# Rezoning Transportation Analysis

Petition Number: 2023-088

Date	Description
07-26-23	First Review (PM)
08-24-23	Second Review (NK)

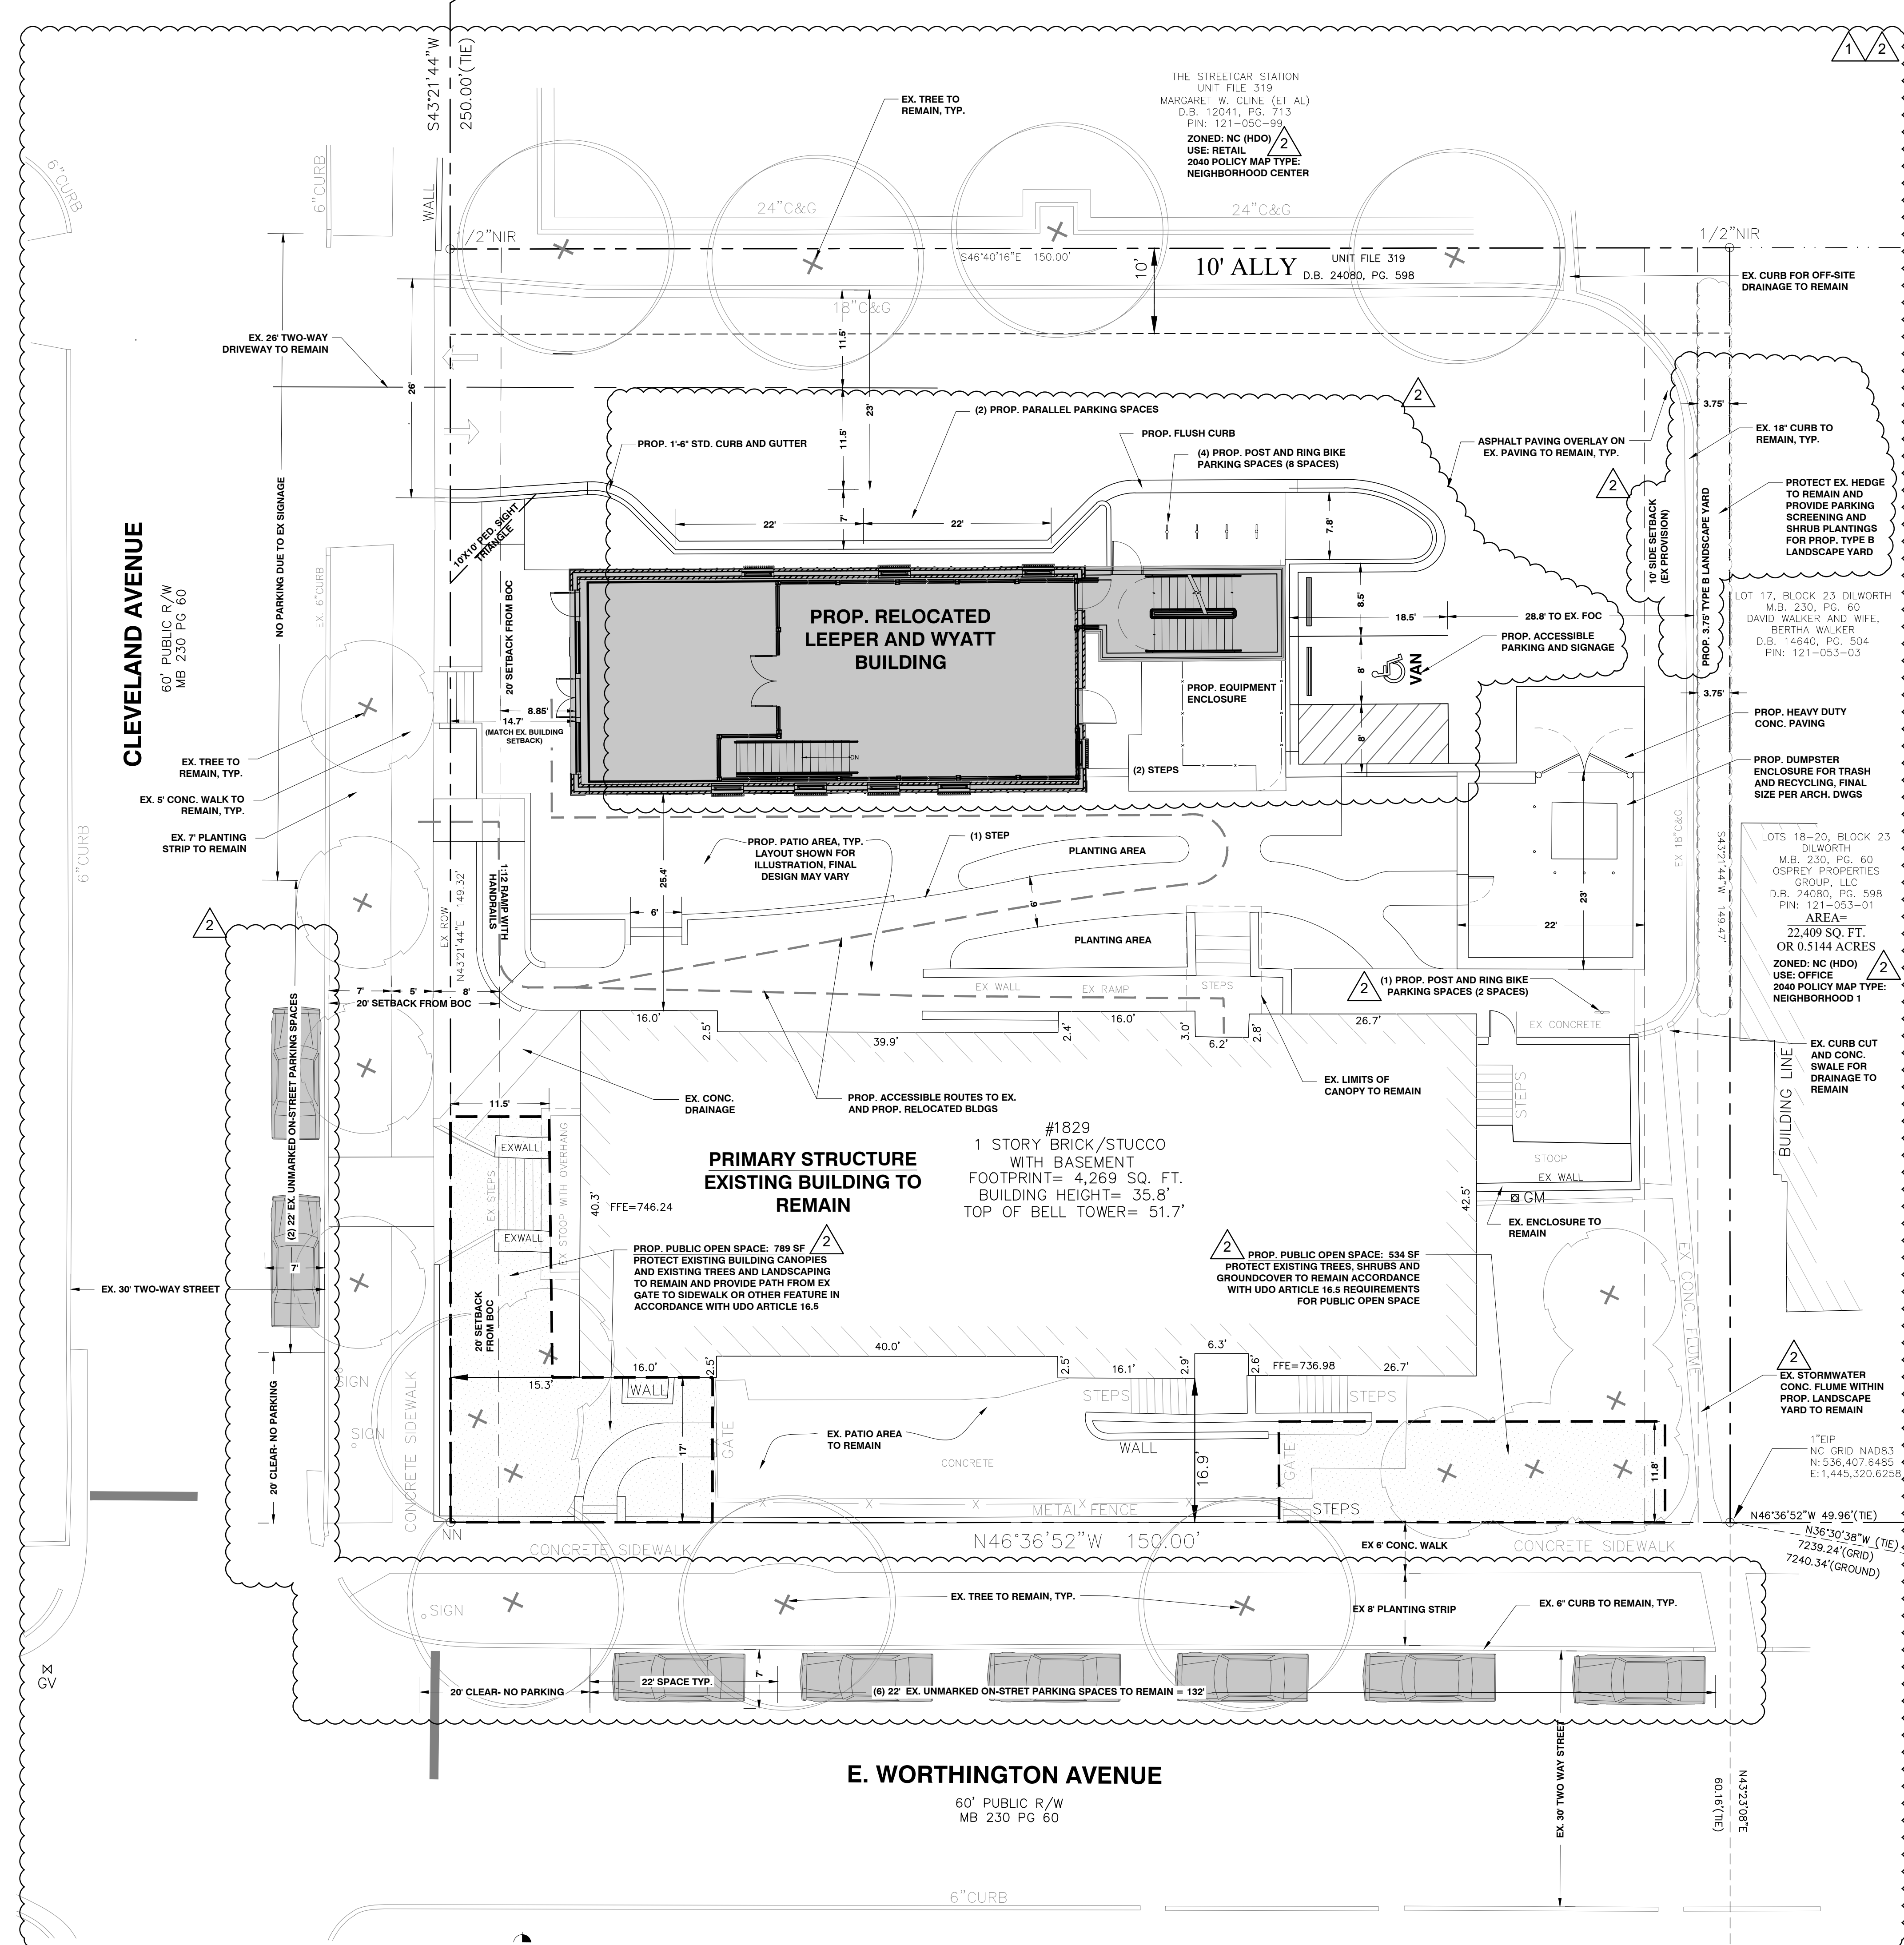
**Clarifying Comment 8/24/23:** Cleveland and Worthington Avenues are both shown as 30' wide streets on current site plans. These streets must be at least 41' wide from back of curb to

back of curb per CLDM U-05. Additionally, each road must label and dimension future back of curb location to the centerline.

- Outstanding Issue 7/26/23:** Add a conditional note specifying "A Right-of-Way Encroachment Agreement is required for the installation of any non-standard item(s) (irrigation systems, decorative concrete pavement, brick pavers, etc.) within a proposed/existing City-maintained street right-of-way by a private individual, group, business, or homeowner's/business association. An encroachment agreement must be approved by CDOT prior to construction/installation. Contact CDOT for additional information concerning cost, submittal, and liability insurance coverage requirements."
- Outstanding Issue 7/26/23:** Revise site plan to show the centerline on each public street. Dimension the right-of-way and the back of curb from the centerline.
